From: Sarah Burrow <Sarah.Burrow@arun.gov.uk>
Sent: 11 May 2021 10:17
To: Planning.Responses <Planning.Responses@arun.gov.uk>
Cc: Amber Willard <Amber.Willard@arun.gov.uk>
Subject: RE: Planning Consultation on: FP/66/21/PL

Engineers Comments Regarding Surface Water Drainage

Application No: FP/66/21/PL

Description of Works: Revision to previously approved scheme (FP/231/20/PL) to raise the ridge height of the development for new building with first floor 1 No. 1- bed apartment above (3 x No.) garages & cycle store with parking. This site is in CIL Zone 4 (Zero Rated) as flat.

© This drawing is copyright and may not be reproduced without written authority		
Scale	As shown	At original A3
Drawing Number	2020/SK5	Revision -

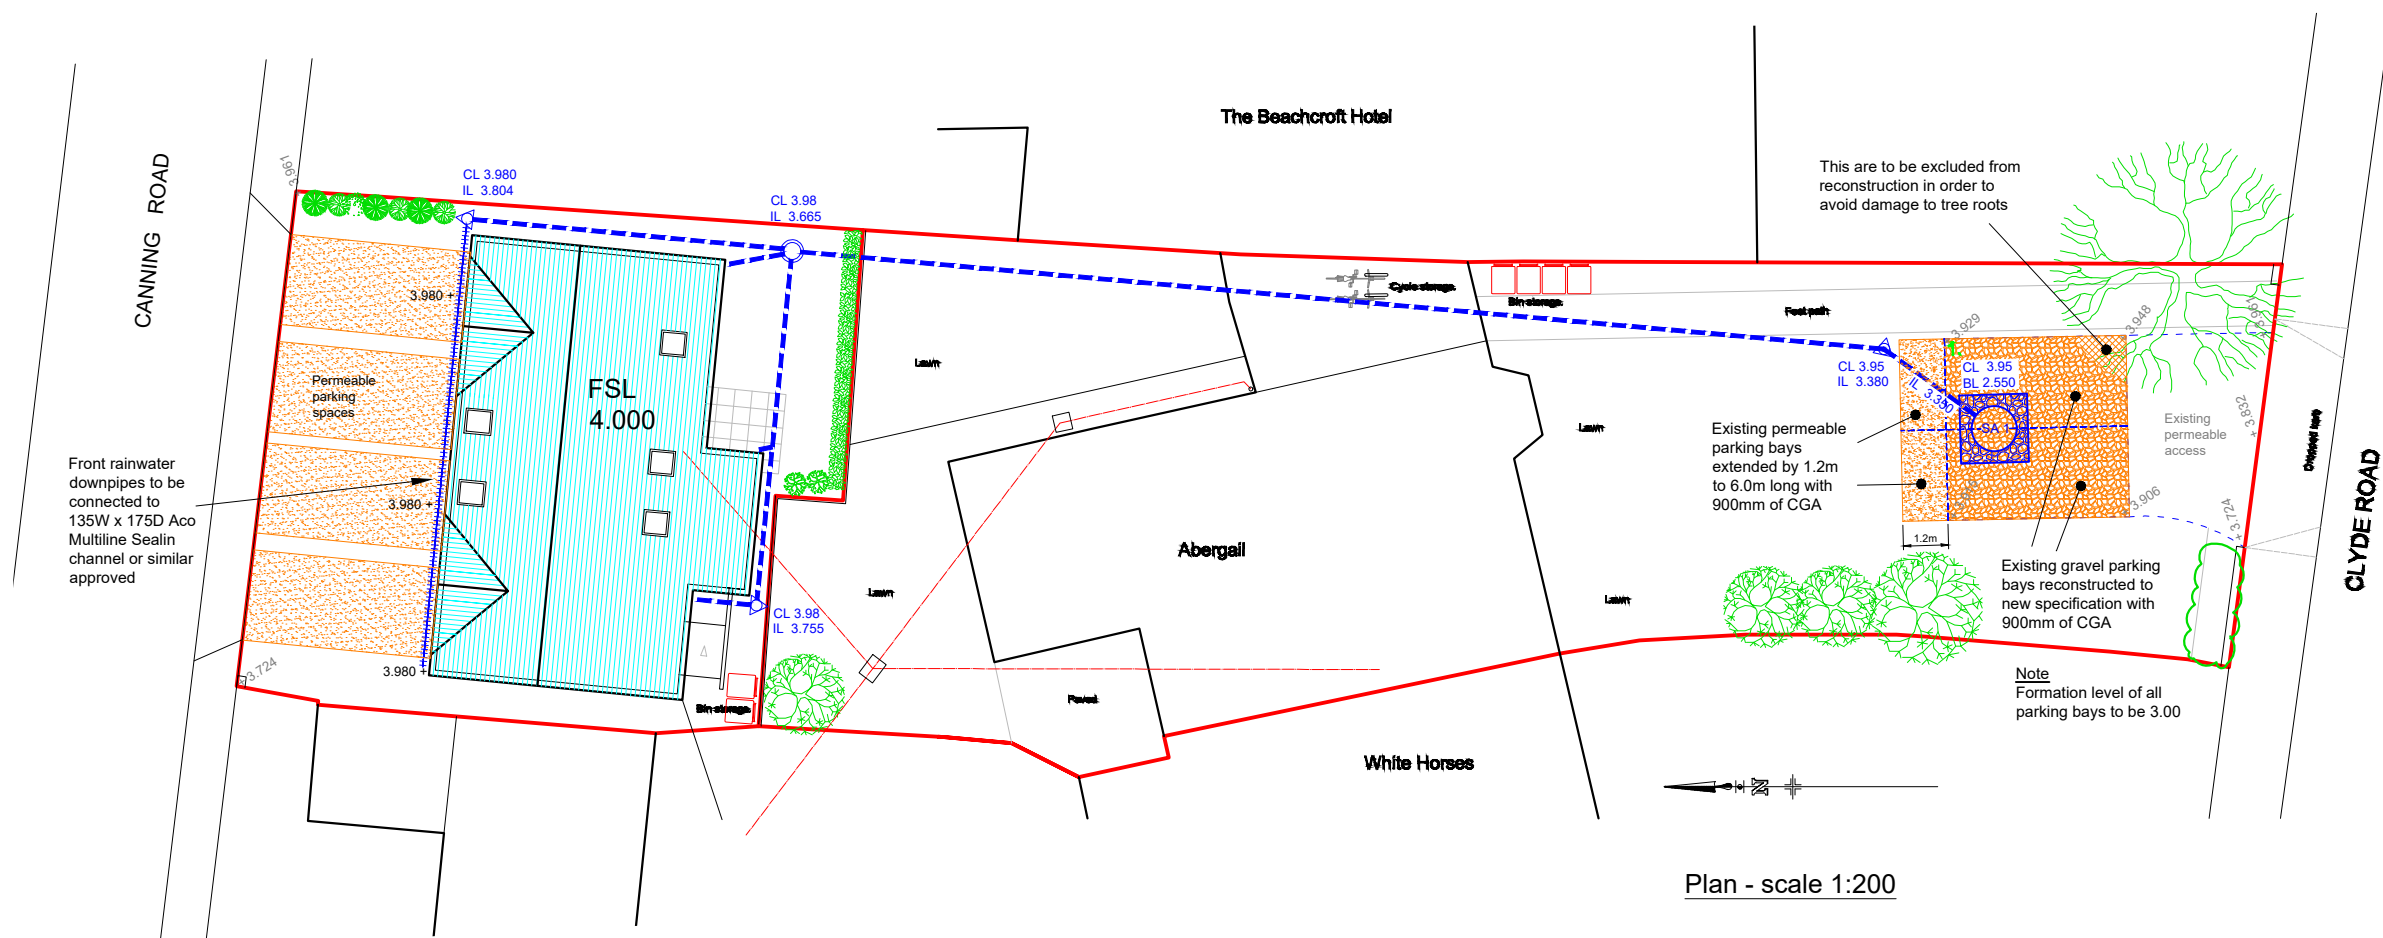
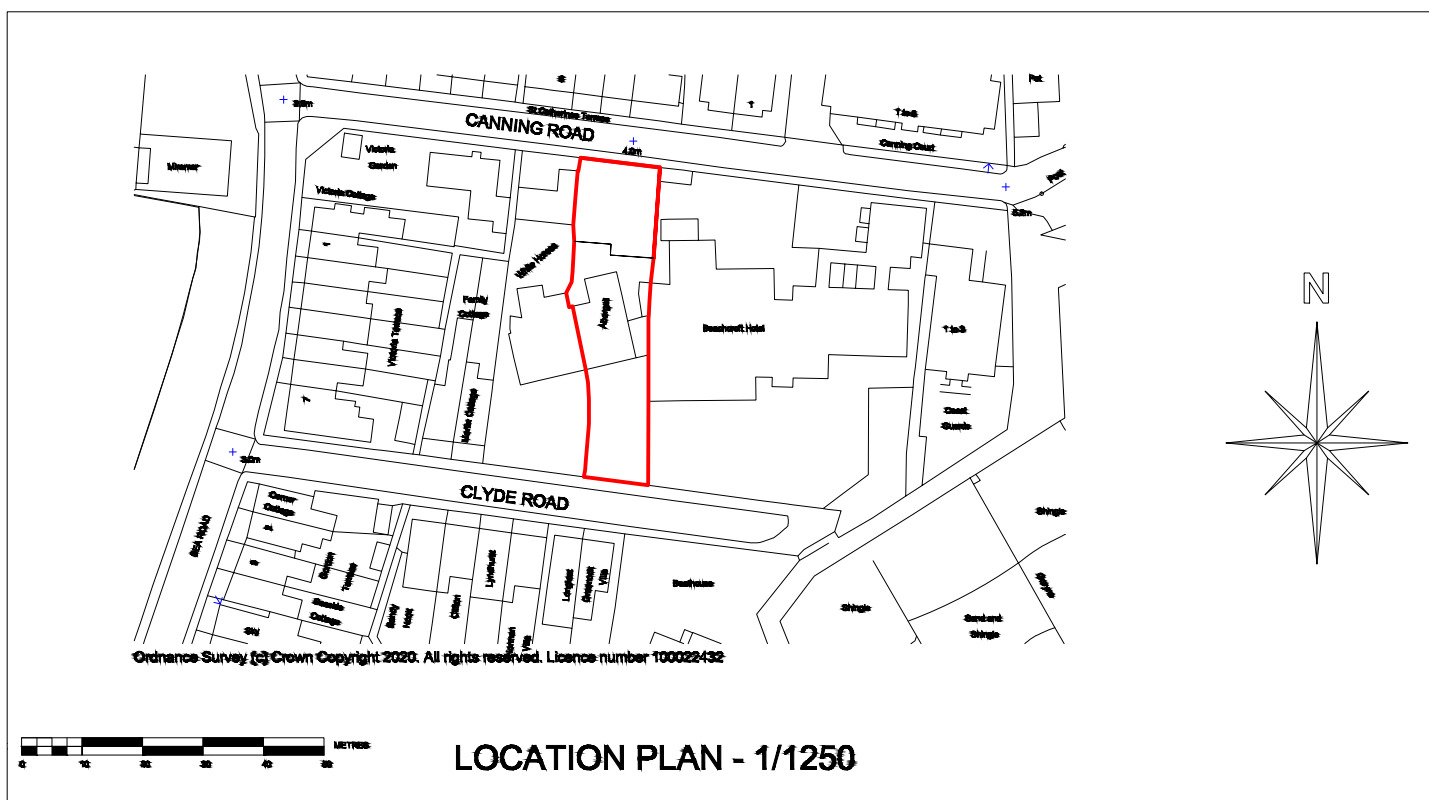
The surface water drainage design and calculations are acceptable. It is worth noting that although the base of the soakaway is set deeper than the highest recorded groundwater this additional depth has not been allowed for within the calculations.

Note: we normally expect to see the gradients of pipes detailed on the Drainage Layout, however, for a proposed development of this size I am prepared to accept that this can easily be deduced from the supplied invert levels and will not be requesting the addition on this occasion.

Note
Permeable paving design is for hydraulic purposes only. The structural design will depend on the loads it is required to take and the strength of the formation and is to be carried out by others

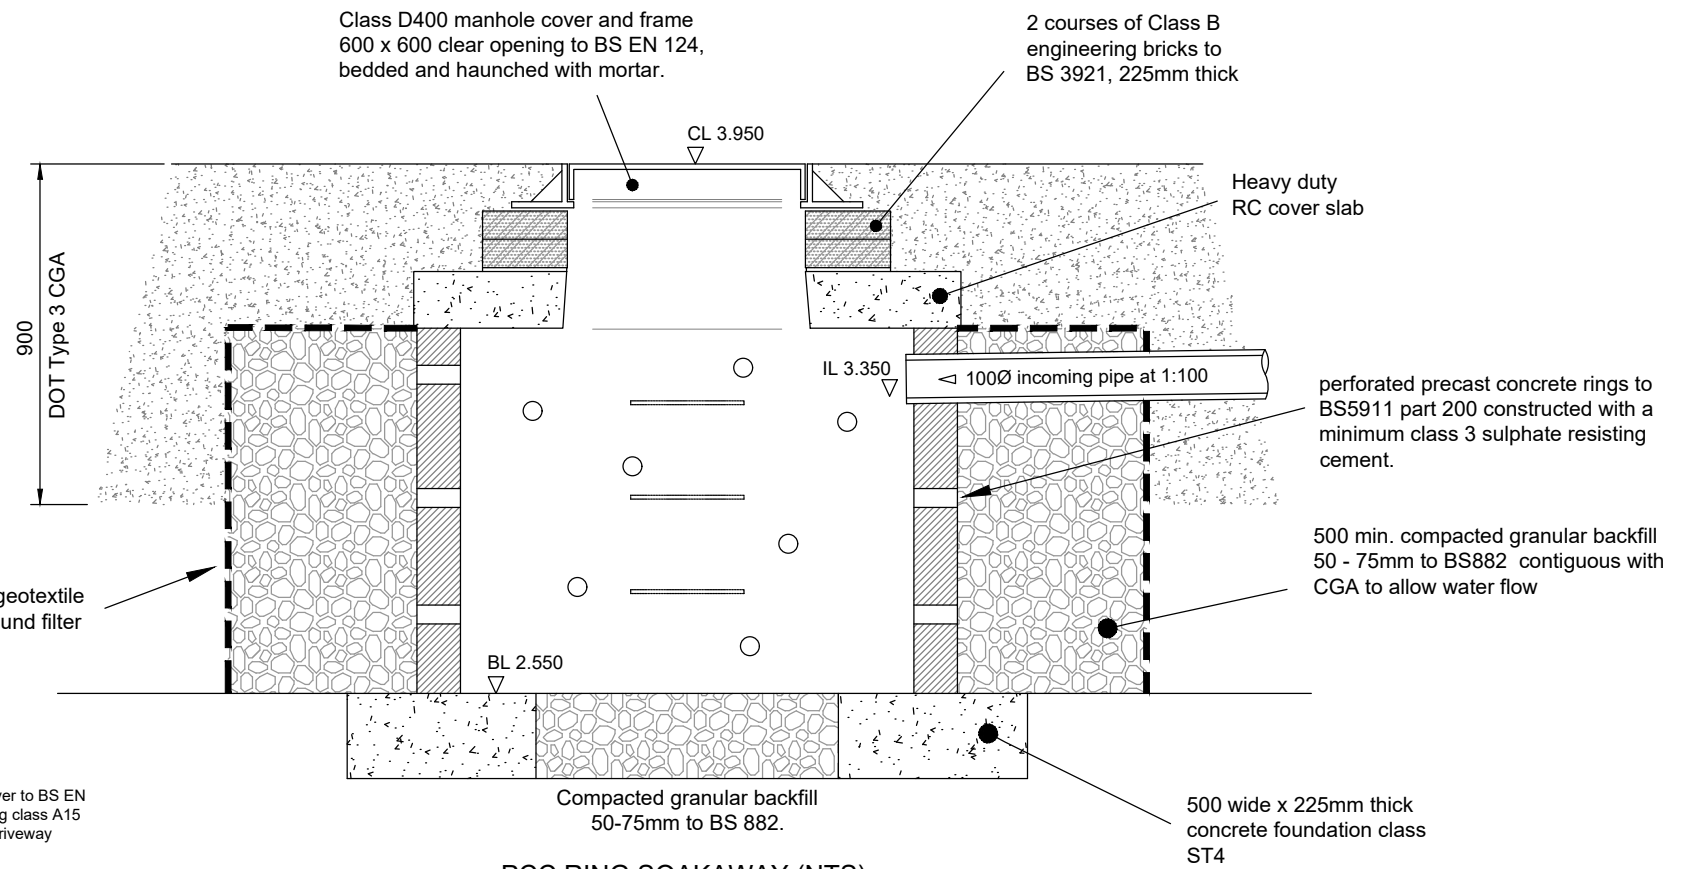
1. Construction detail drawings of:
 - a. ACO channel
 - b. Class Z pipe bed and surround
 - c. Permeable paving (the note regarding structural loadings is noted, however, we would expect to see a detail showing the different courses and minimum depths required for hydraulic purposes).
 - d. Invert level and diameter of incoming pipe shown on soakaway detail.
